From: Fiona Pudge [Fiona.Pudge@sportengland.org]
Sent: 29 May 2012 14:51
To: Graeme Thorpe
Subject: RE: Sport England Response to App 3/2012/0225 Langho FC

Sport England welcomes the inclusion of recessed goals which allows a slightly larger pitch area.

Langho Football Club
Proposed Layout Scale 1:250

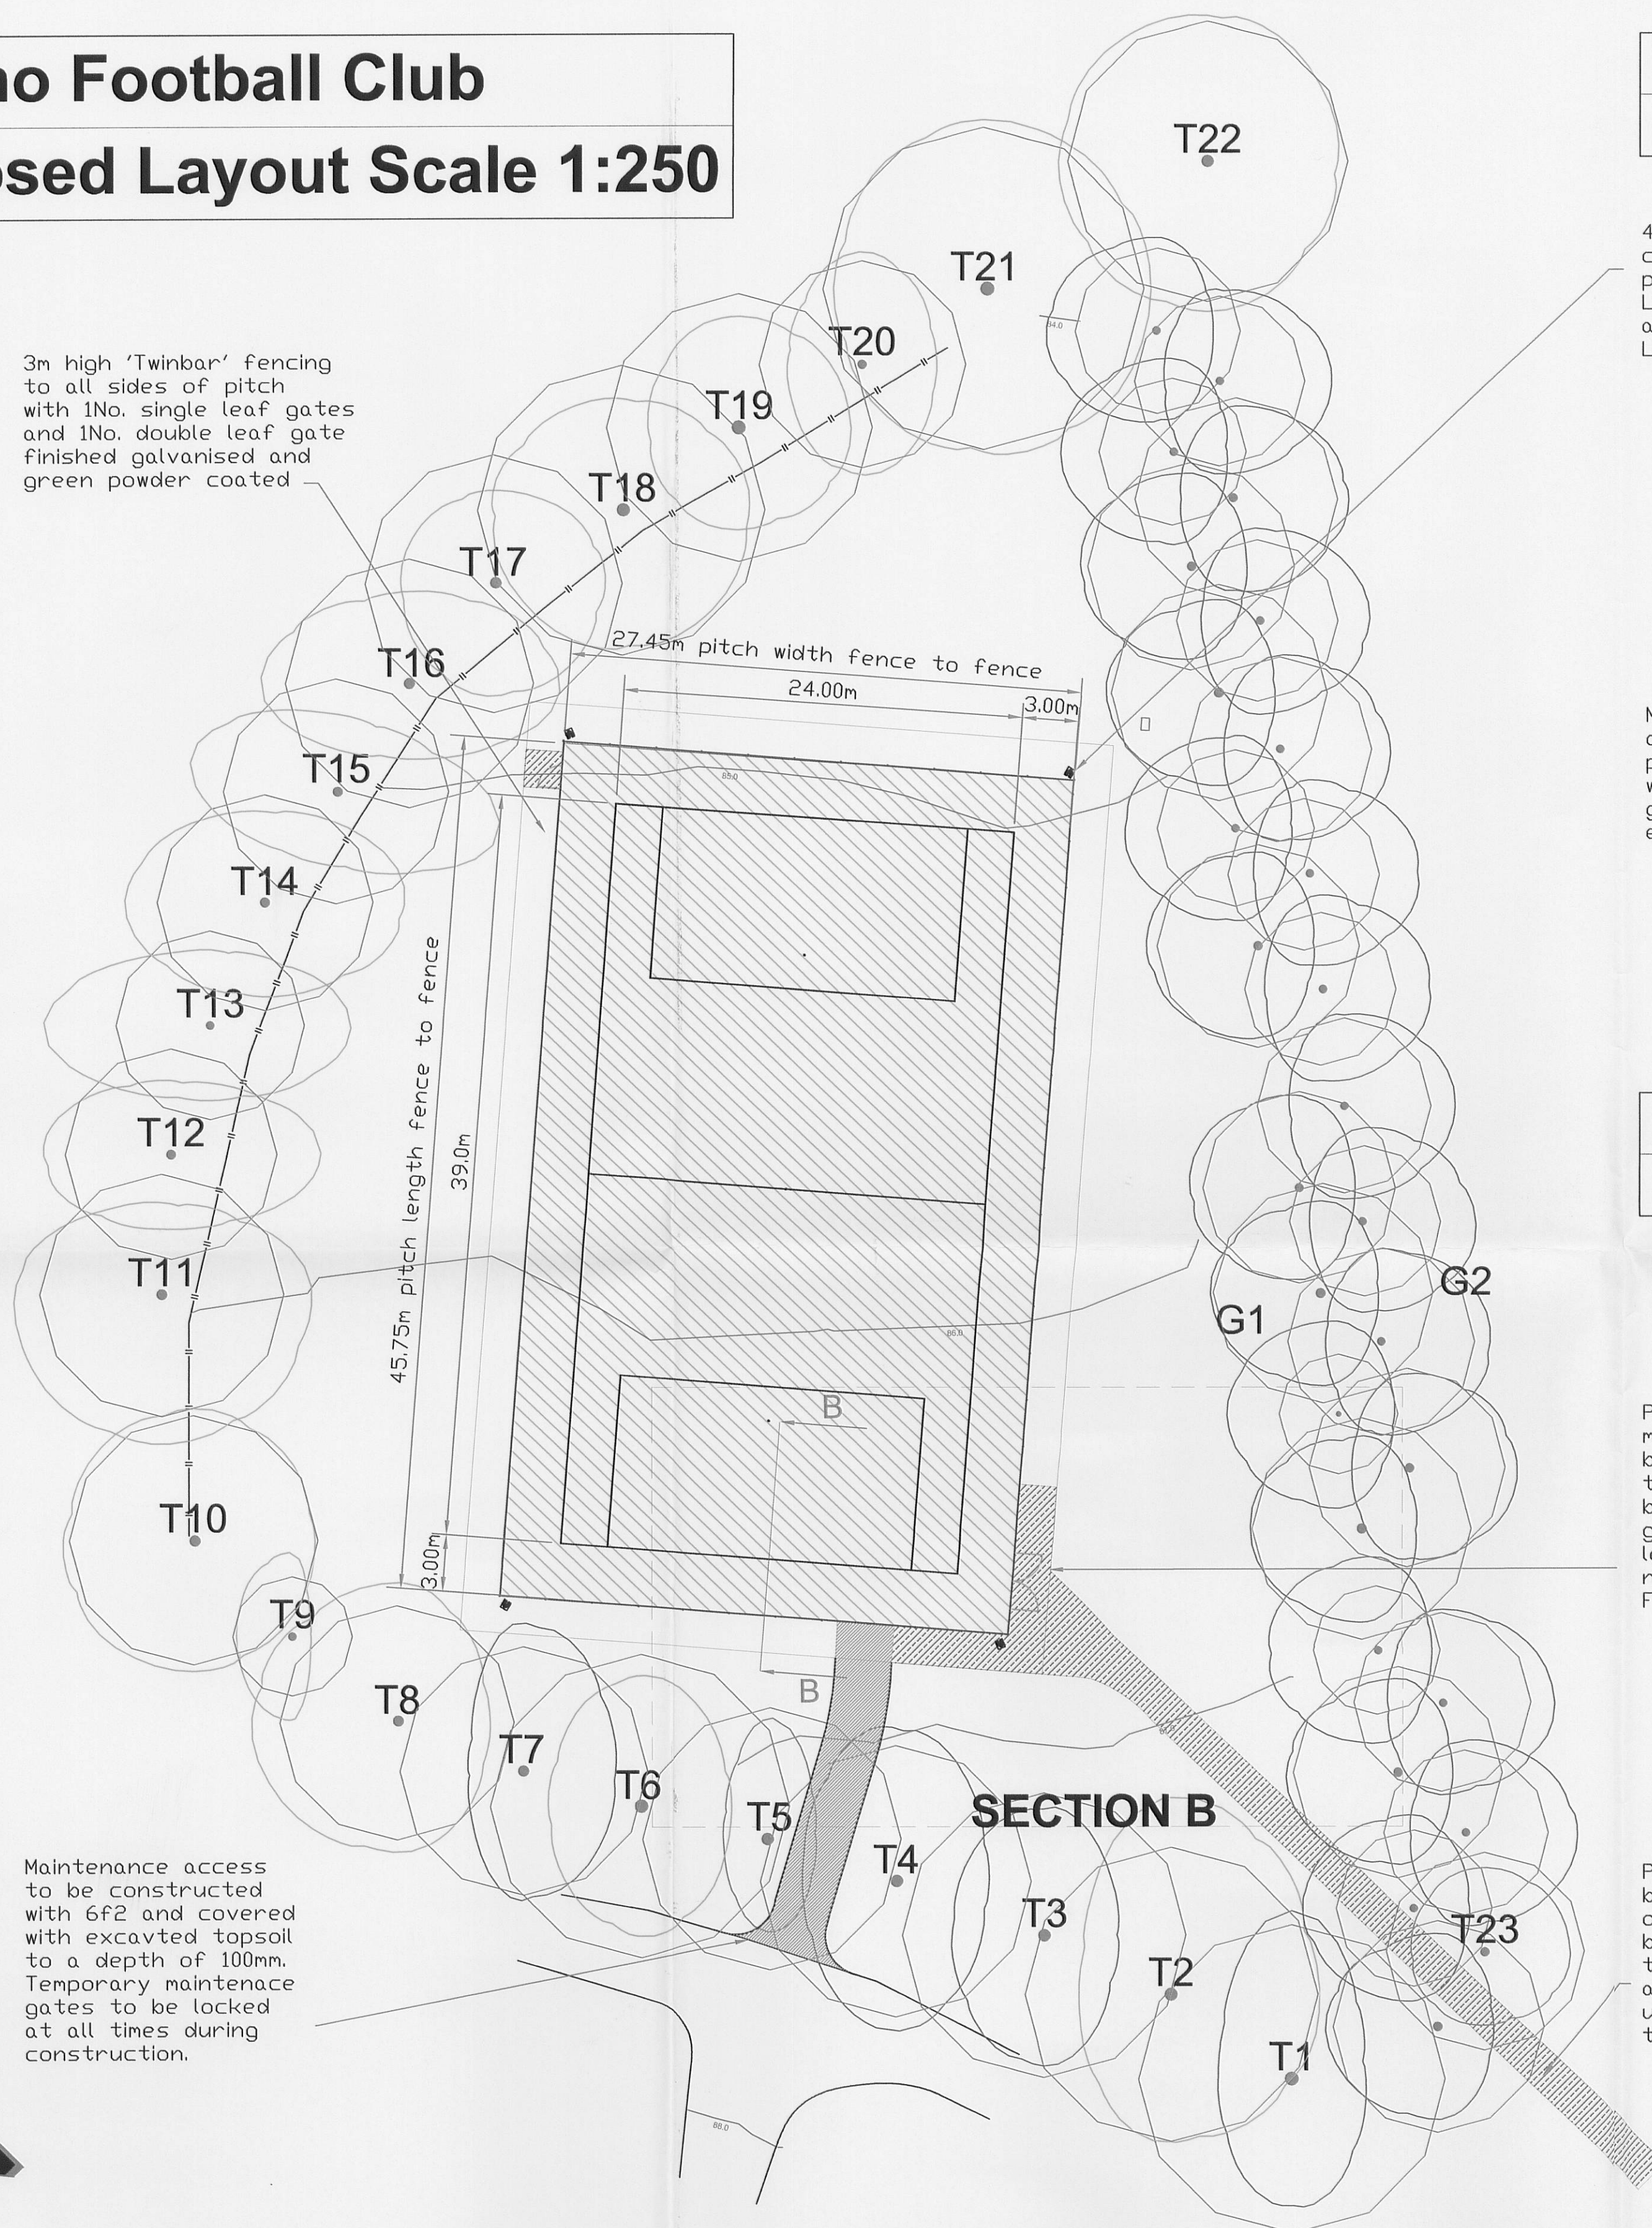
I can confirm the comments made in my correspondence of 3rd May 2012 remains unchanged and the condition requiring materials and construction details of the AGP prior to commencement is still required.
